Our Case Number: ACP-323830-25

Re: Proposed flood relief scheme
in Mountmellick, County Laois

Re: Submission on Mountmellick Flood Relief Scheme

Figure 3-2: Flood Defences, Compound Locations and Access Points

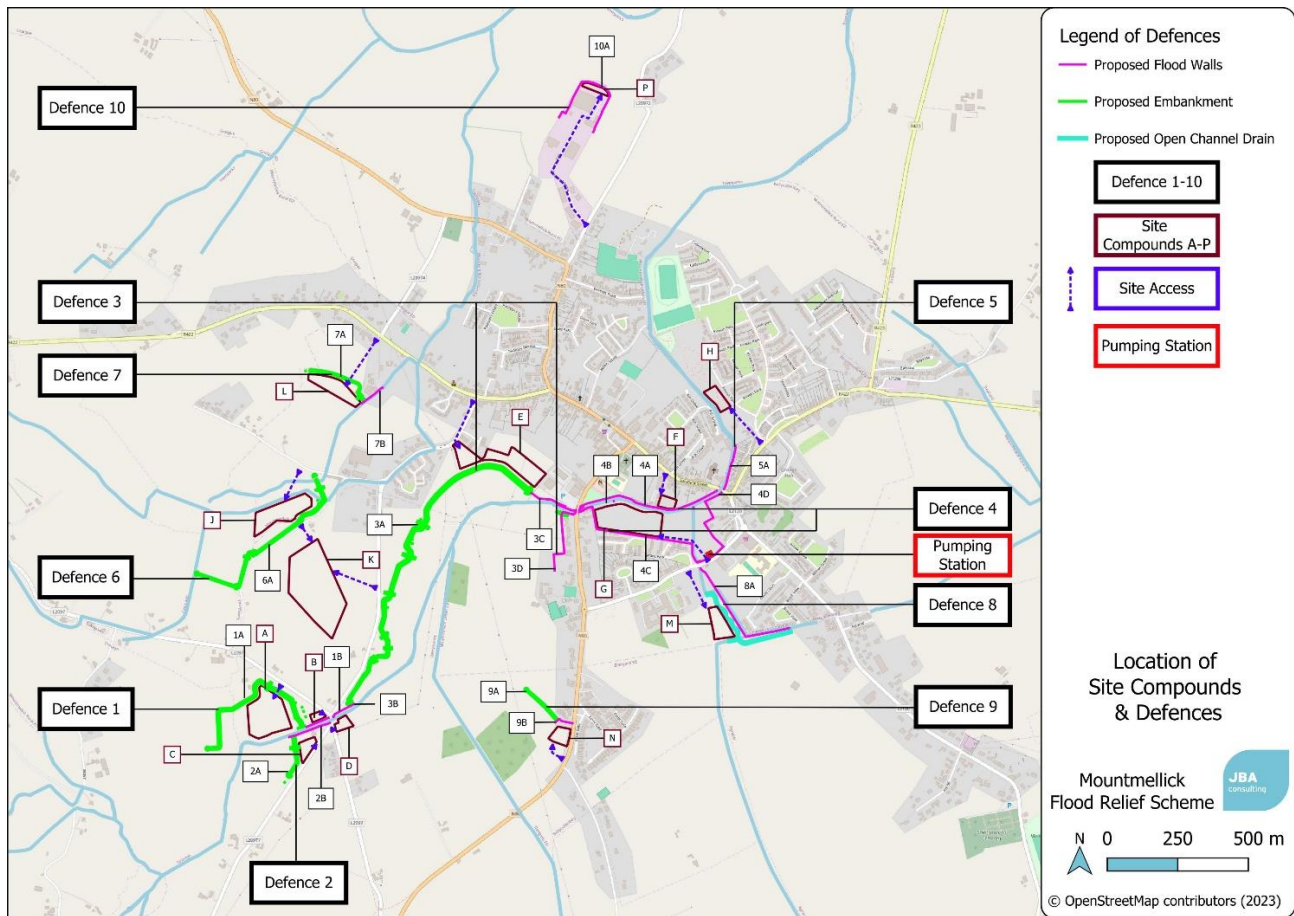
Why are the temporary storage areas so large and other smaller parts of fields left with no access to them? How is one supposed to access them?

Figure 6-3: Diversion routes during the Owenass Bridge Replacement

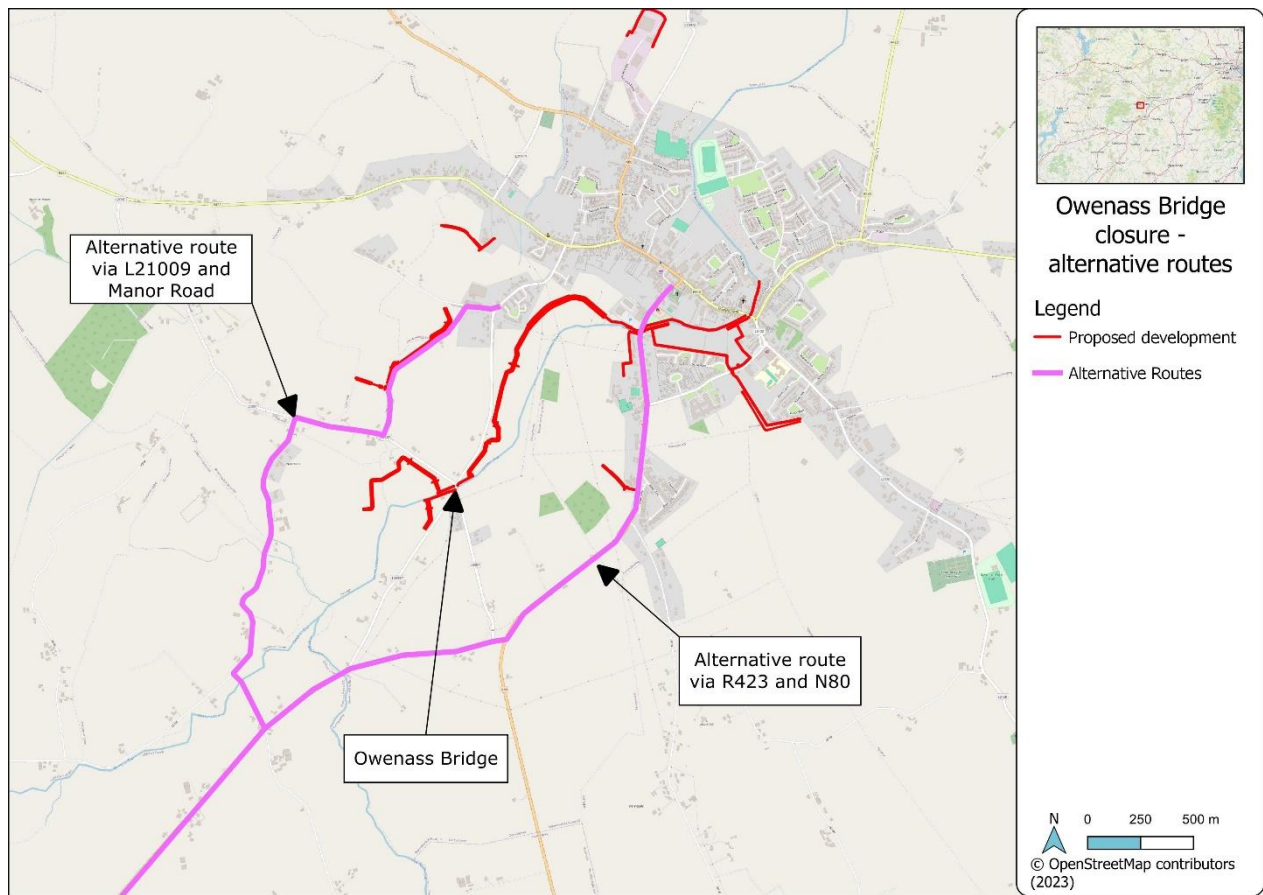
Traffic will be very busy in the town while the Owenass bridge works take place. I am concerned about a map showing an alternative route to access Mountmellick from the Portlaoise side using a narrow one car wide lane from the Ballyfin road past New mills and down sandy lane to Manor road.
